RE: 9440 Bur Oak Ln 20% Setback Reduction

File: ADR226
Parcel ID Nos.:5515403027

This is to inform you that the above referenced request for approval of an application for administrative relief to allow:

1. A rear setback of 16' feet where 20' is the minimum setback requirement for a detached garage within the PUD (Planned Unit Development) zoning district.

9440 Bur Oak Ln - Site Plan

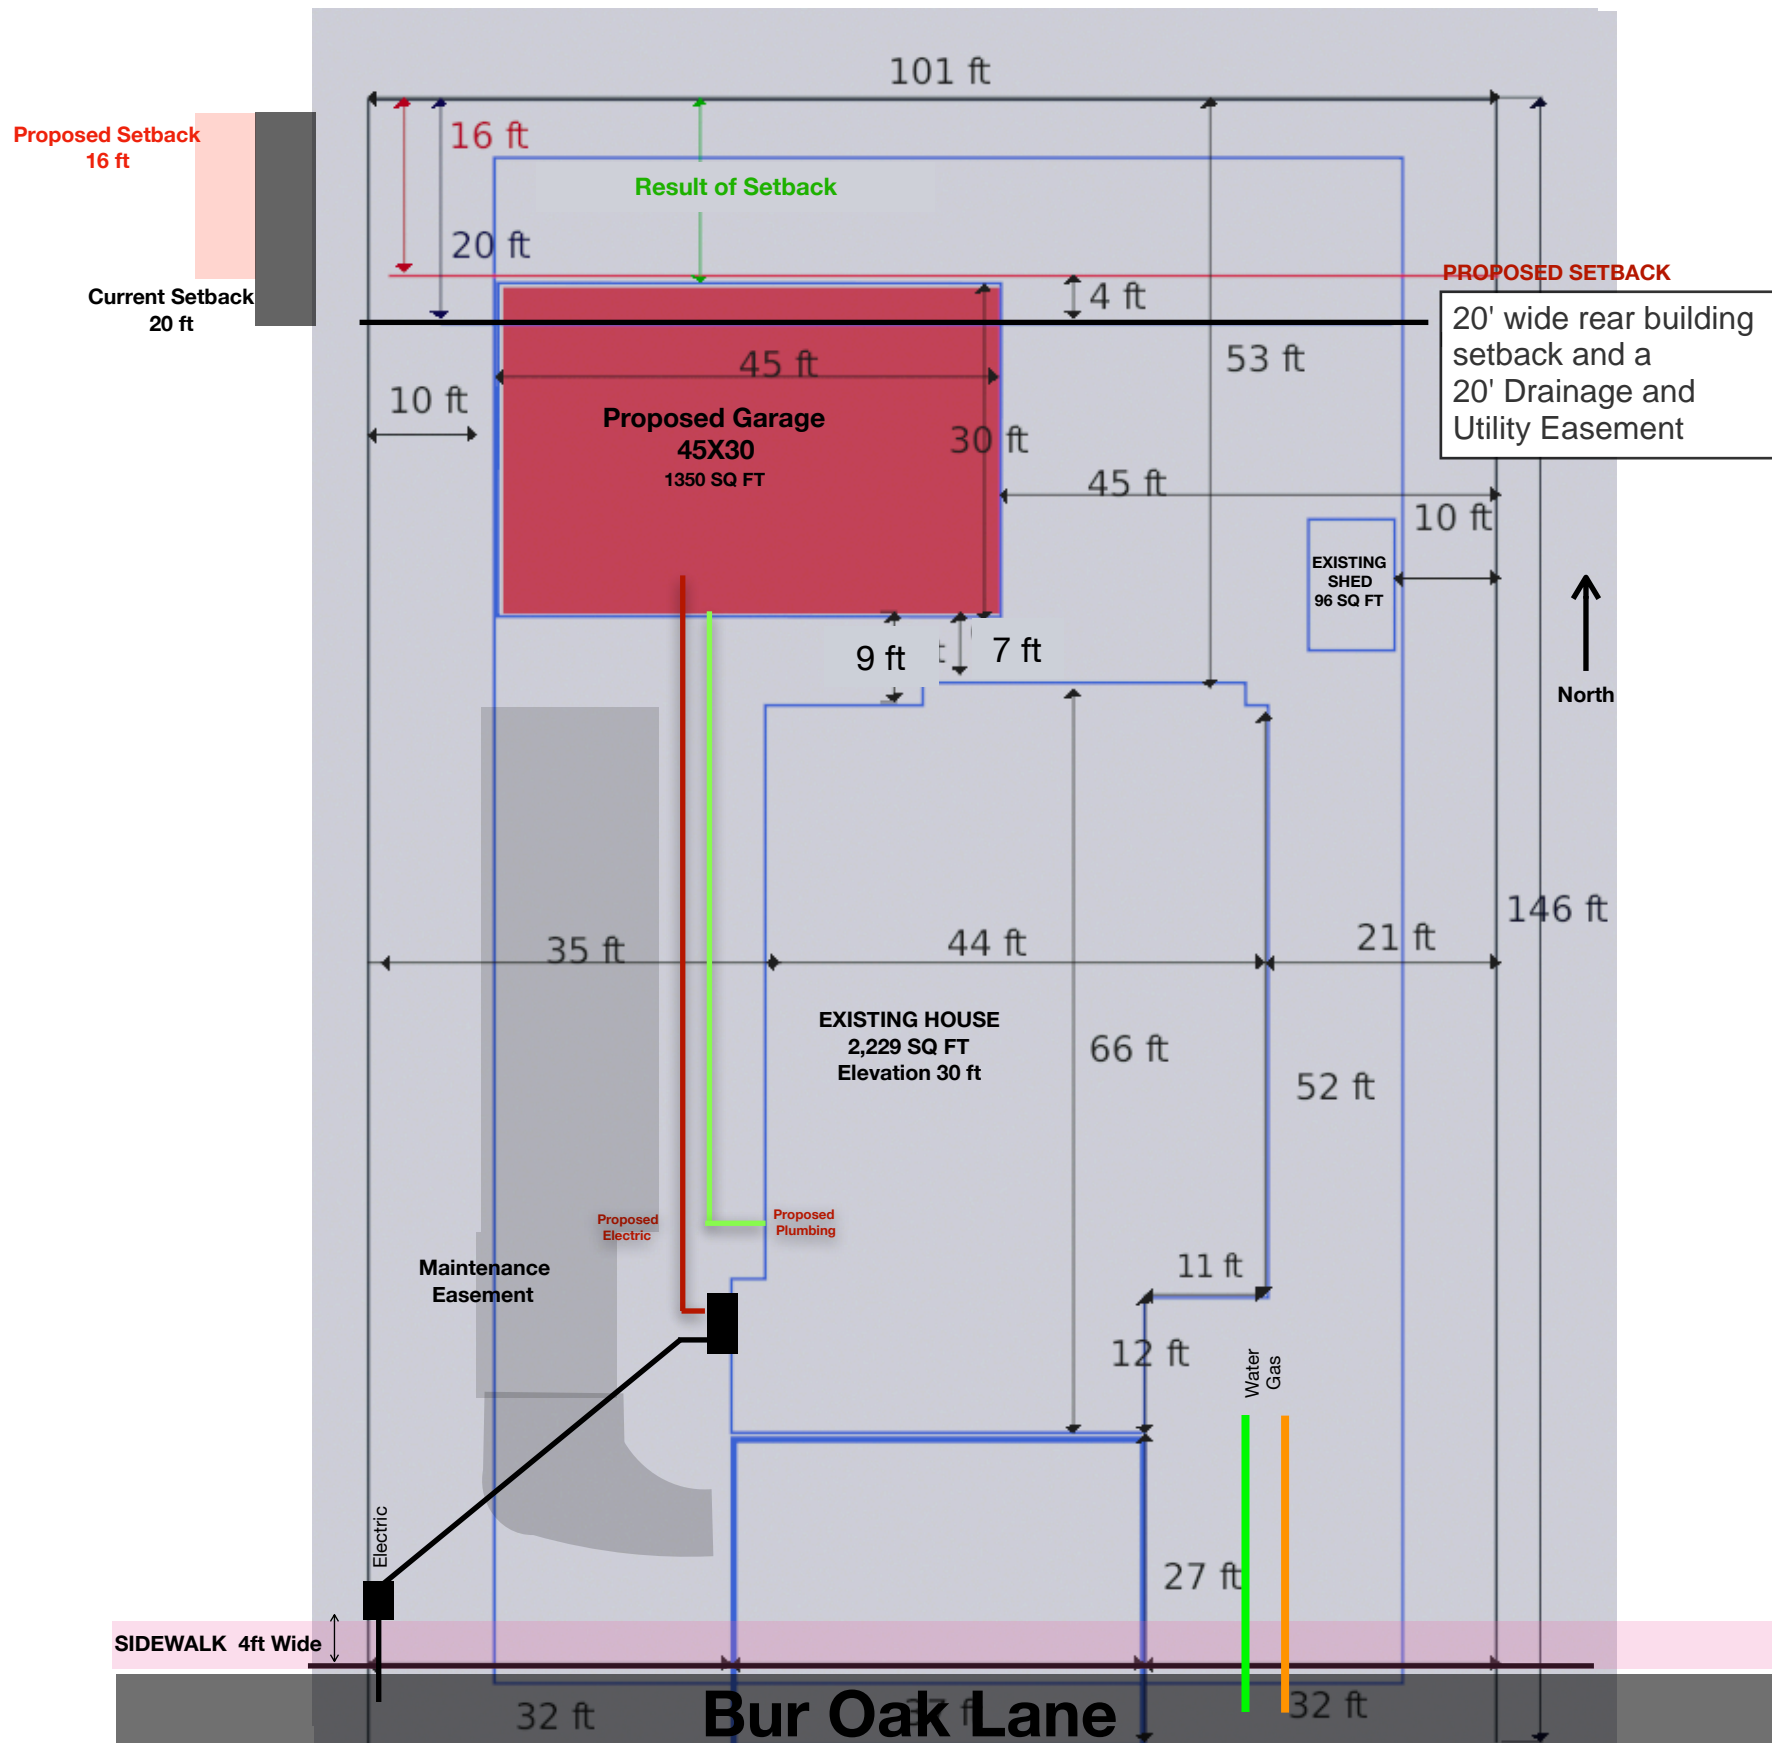
1. Any expansion or additions beyond the initial construction of the detached single-family dwelling (e.g. deck, garage, sunroom) may require separate application(s) and approval(s) if the development requirements of the PUD zoning district cannot be met.
2. Approval of a site plan by the Planning and Community Development Department and issuance of a building permit from the Pikes Peak Regional Building Department are required prior to construction of the detached garage.
3. The design shall be engineered to mitigate for the swale located within the easement.

4. The design and construction must accommodate the drainage from the north until such time as the area to the north is developed and flow is significantly reduced from upstream. Positive flow to the west must be maintained at all times.
